From: Martin Hill <Martin.Hill@arun.gov.uk>
Sent: 03 February 2021 18:57
To: Planning.Responses <Planning.Responses@arun.gov.uk>
Subject: RE: Planning Consultation on: LU/13/21/PL

Comments from Private Sector Housing:

Application No: LU/13/21/PL

Description of Works: Change of use of existing single dwellinghouse (C3) to an 8-bedroom House in Multiple Occupation (Sui Generis).

Proposed Ground Floor Plan 1:50

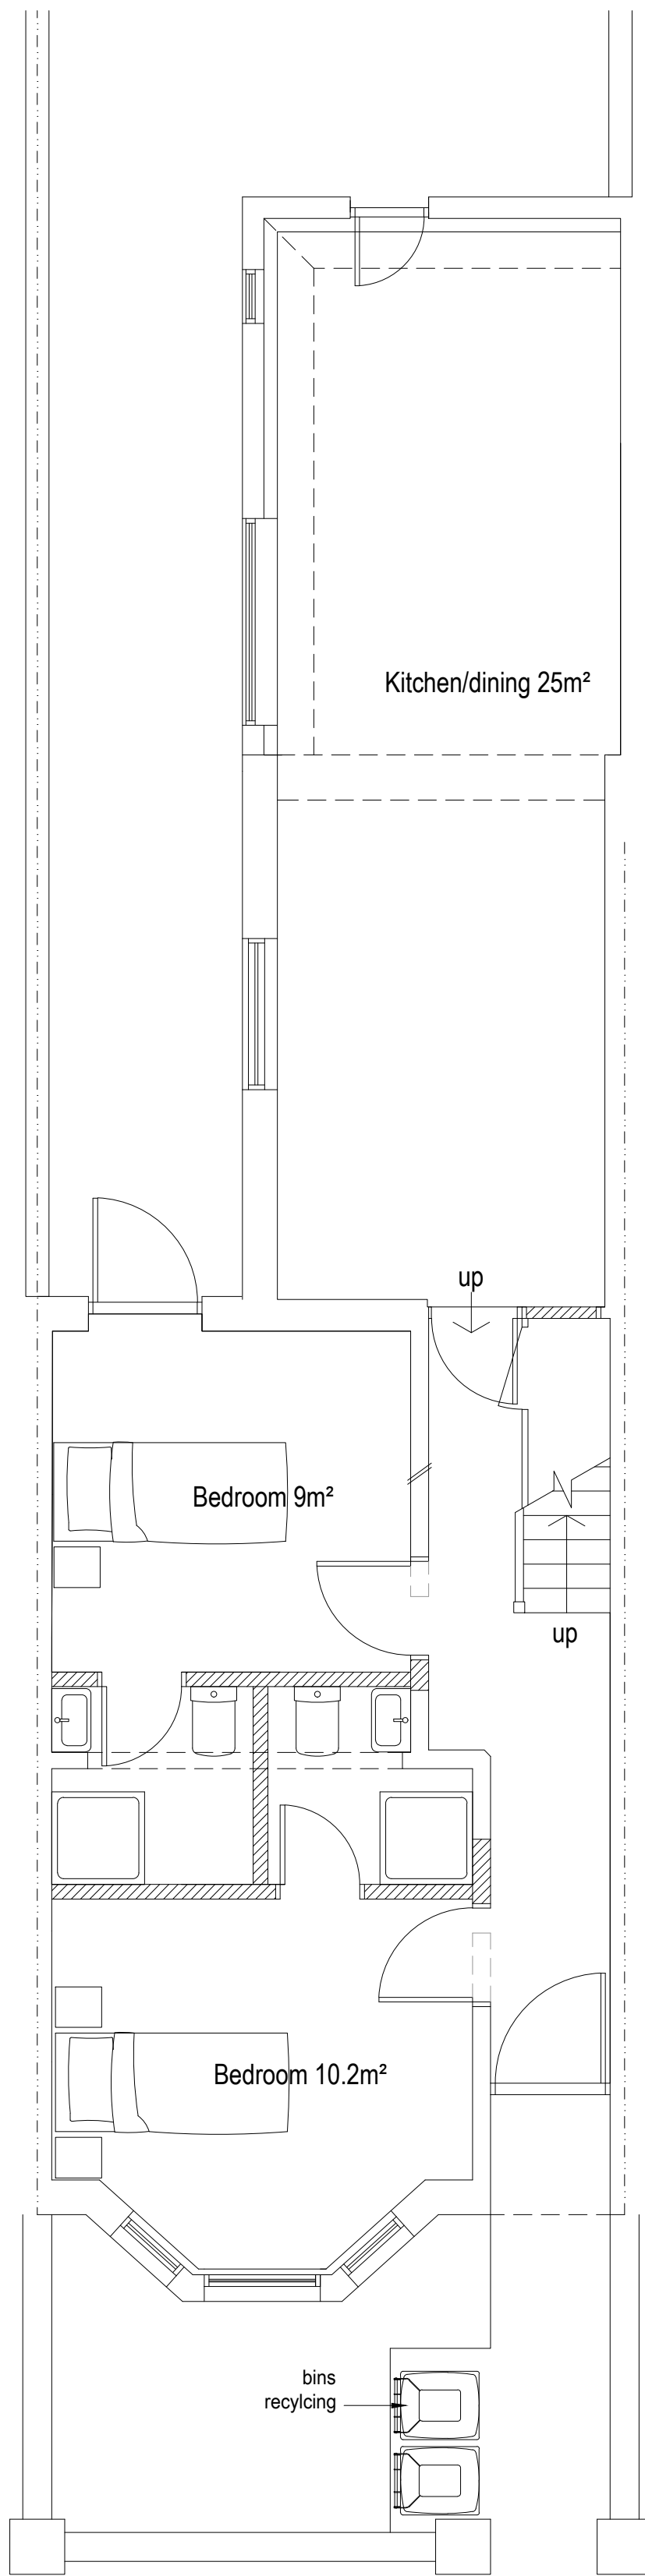
- Emergency escape lighting to be installed along the escape route
- All final exit doors, including the front door, kitchen rear door, ground floor middle bedroom exit door to be fitted with thumb-turn style devices to enable a quick and safe escape without the need for a key, code or card.

- All habitable rooms must have an opening window, equivalent to 1/20th of the floor area, to the outside air to provide adequate ventilation. The windows must provide for a reasonable view, other than those where privacy is required such as in bathrooms for example. French or patio doors that have no separate openable casements, or where there is no alternative openable casement within the room, are not considered acceptable in bedrooms. According to the plans submitted, an openable window could not be identified in the ground floor, middle bedroom in addition to the externally opening door.
